Re: Objection to MP08_0244 MOD 1 Modification Request for Mixed Used Development at 23-37 Lindfield Avenue and 11 Havilah Lane, Lindfield

1 HAVILAH LA ELEVATION
2001 SCALE1 : 250

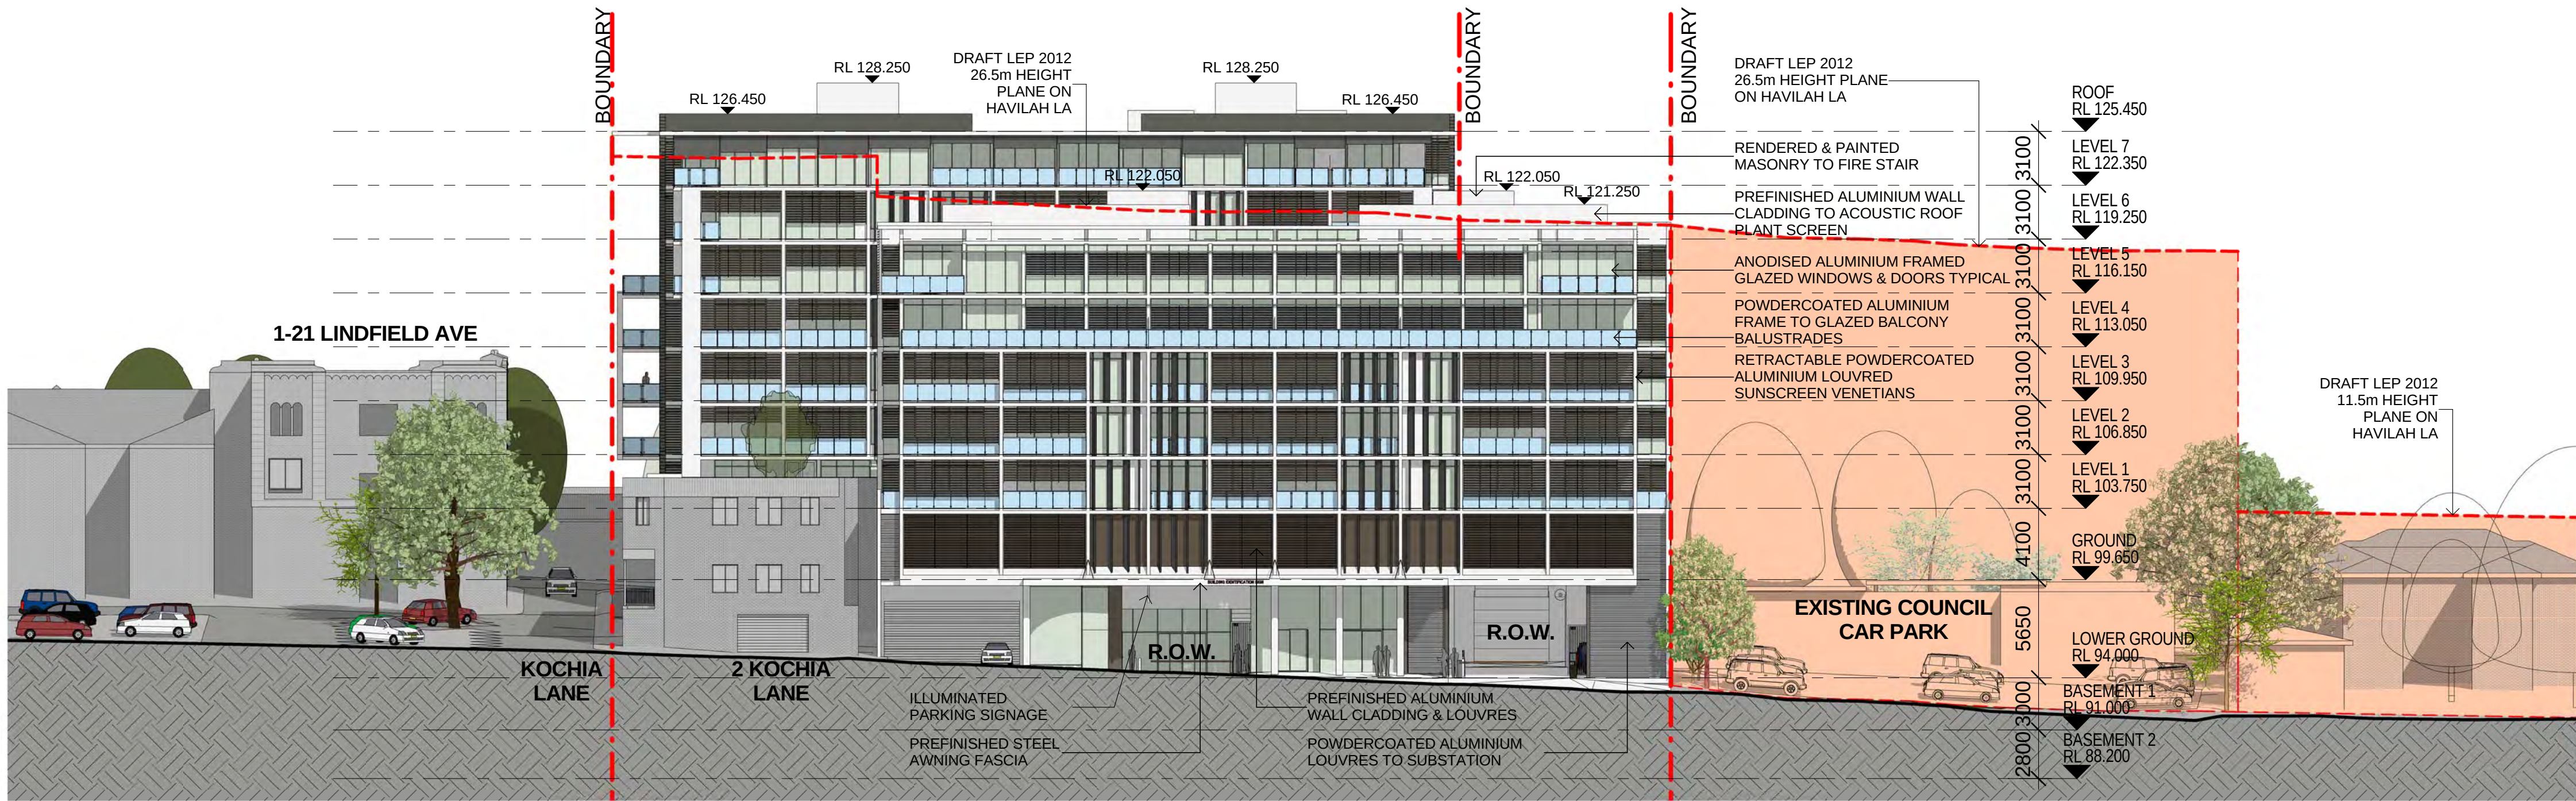
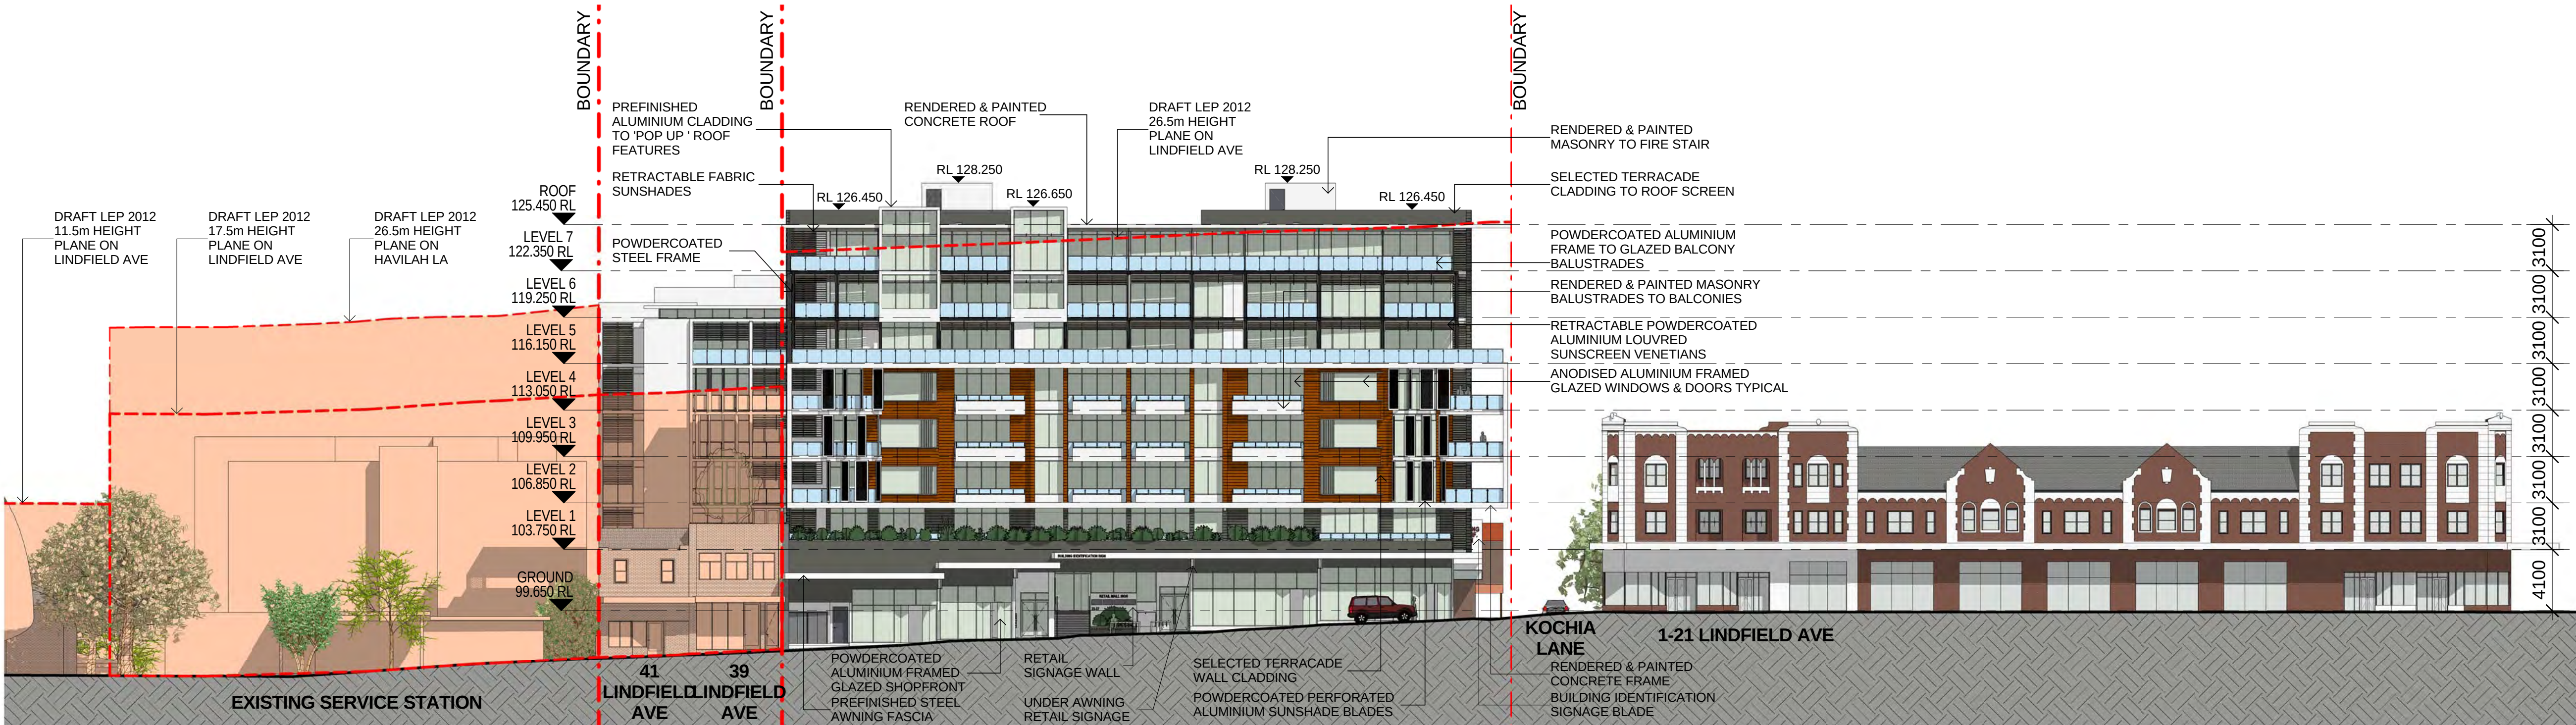
- The increase of an additional storey to both buildings: 8 storeys on Lindfield Avenue and 7 storeys on Havilah Lane creates excessive height and bulk and is out of character with the surrounding buildings, including the heritage listed adjacent building on Lindfield Avenue

1 SHADOW DIAGRAM - 21stDEC_9AM
5003 SCALE1 : 650

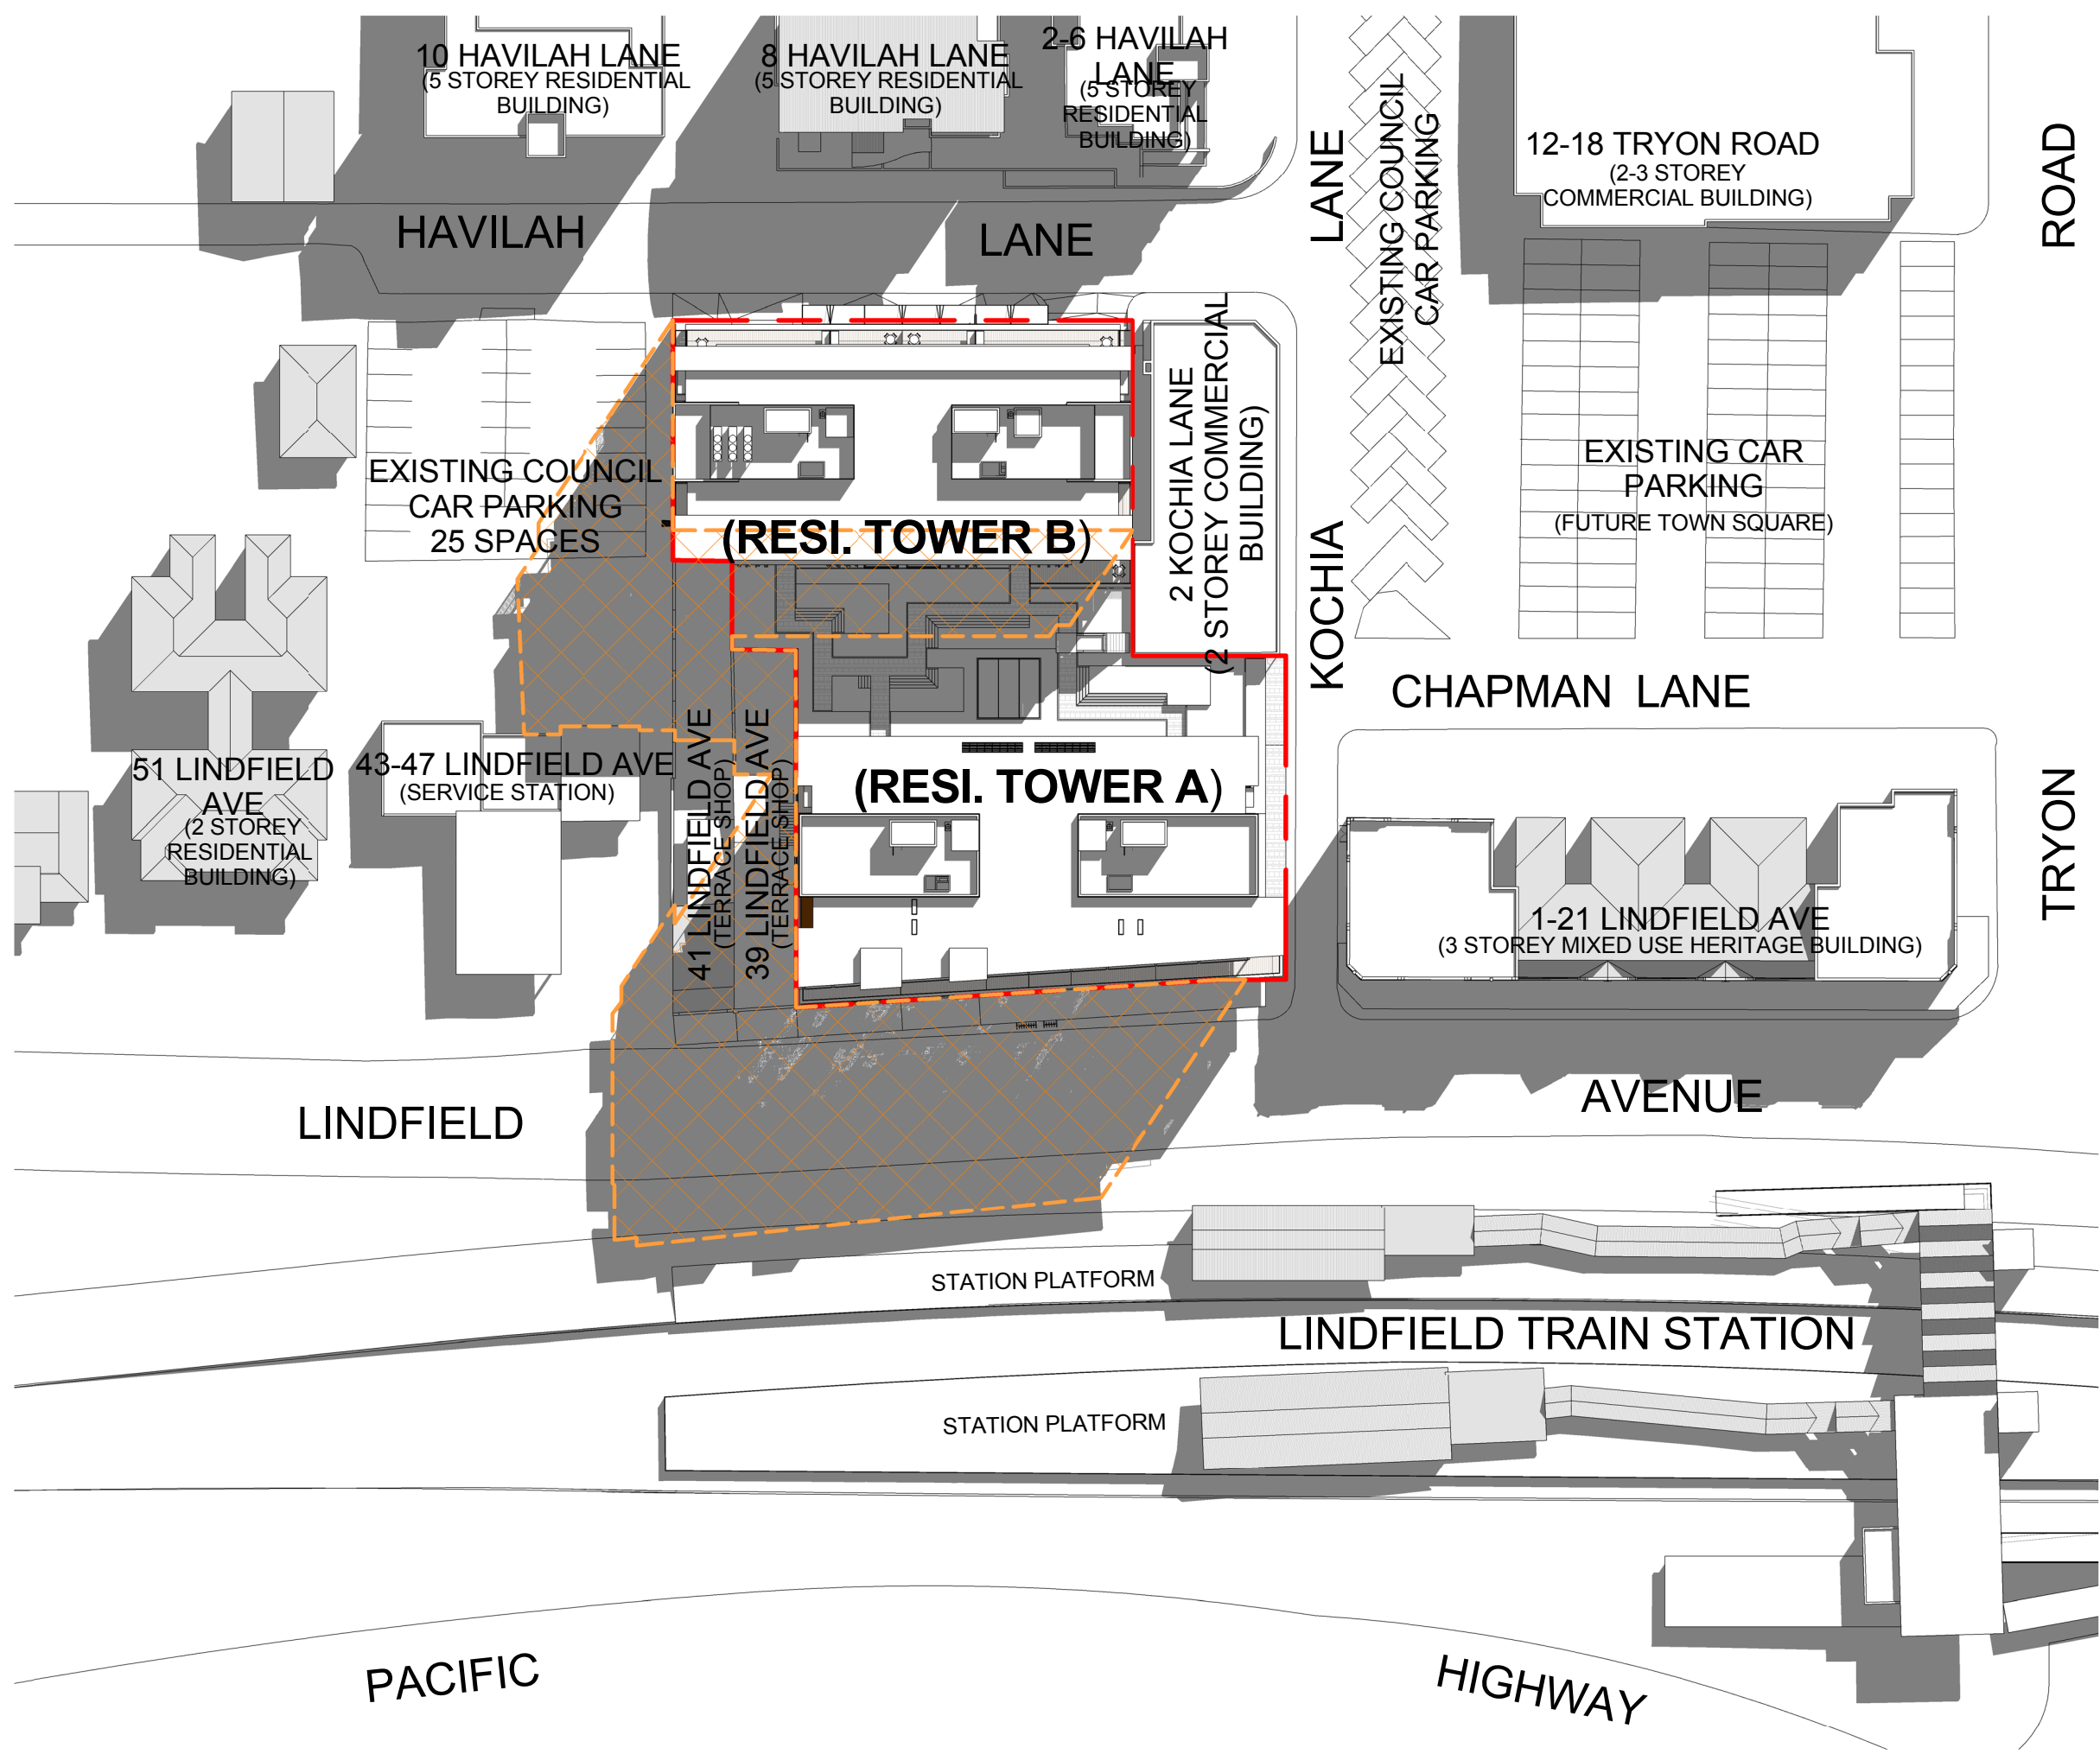
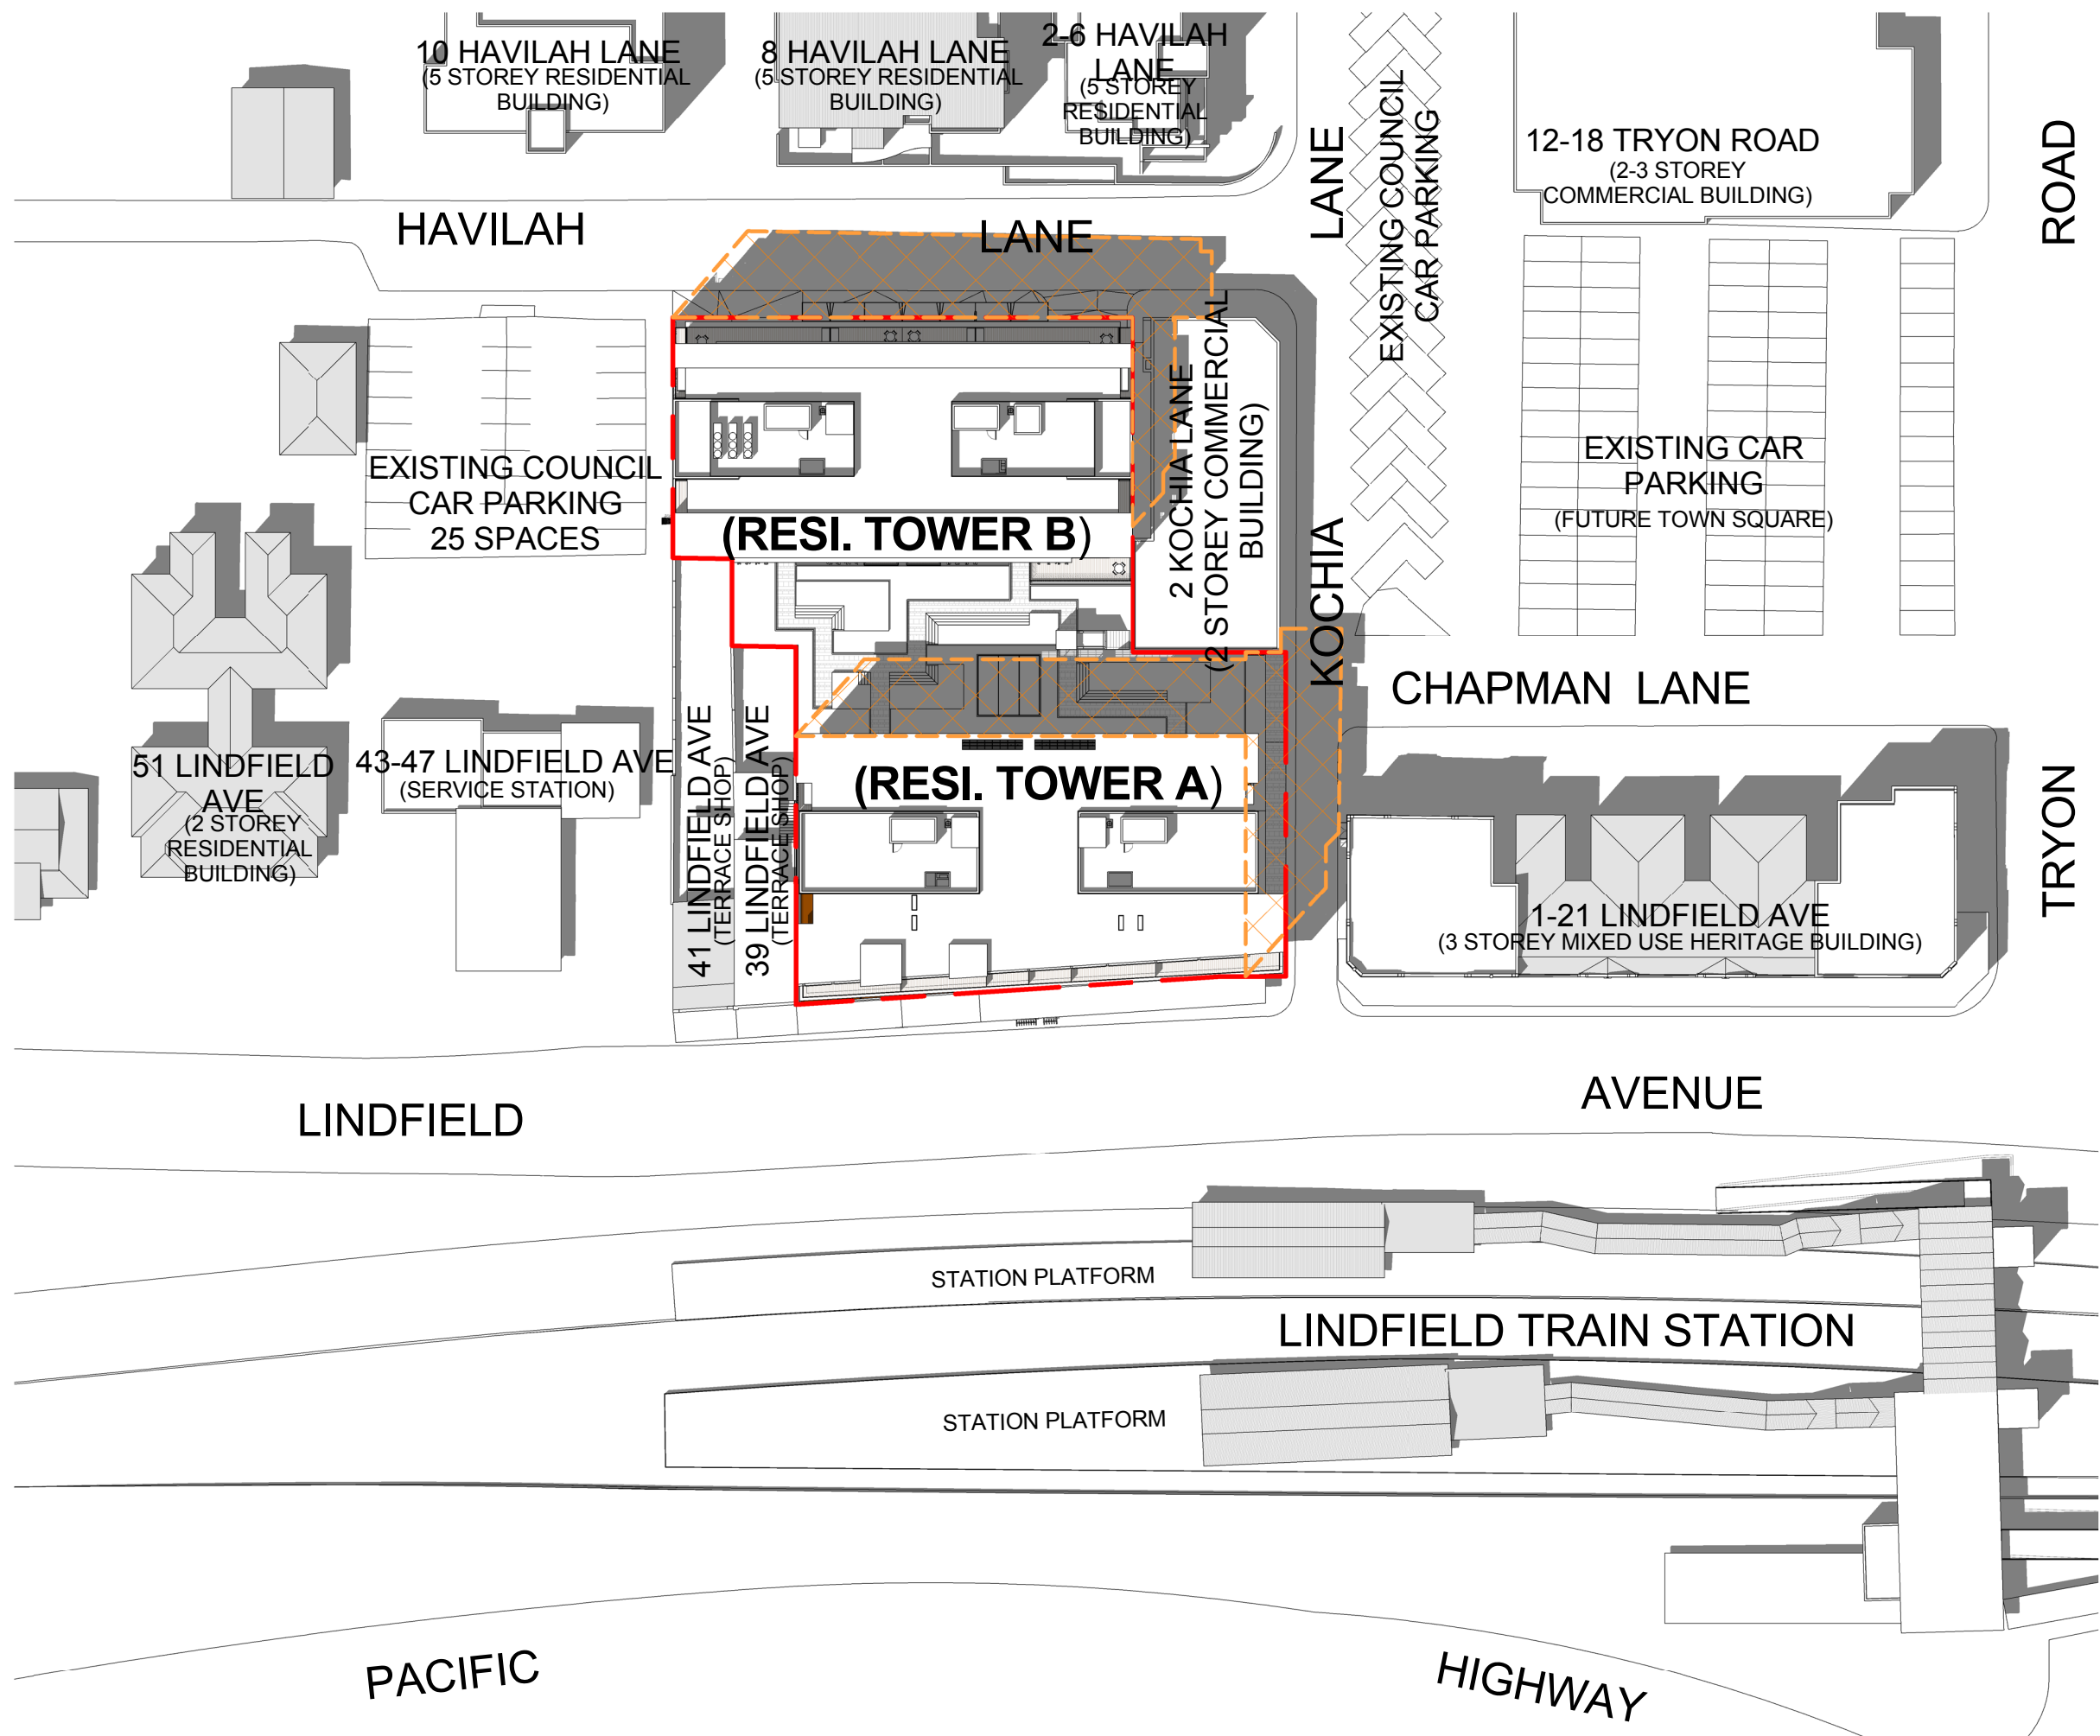
- The additional storeys create new adverse shadowing: a) for residents in the Havilah Lane apartments, particularly after 3pm b) for the popular outdoor café and central Lindfield hub area at 12 Tryon Road in afternoons, particularly in winter and c) for all commuters on the city bound Lindfield rail platform, instead of 50% of the year as approved, it will now be in shadow in the mornings 75% of the year
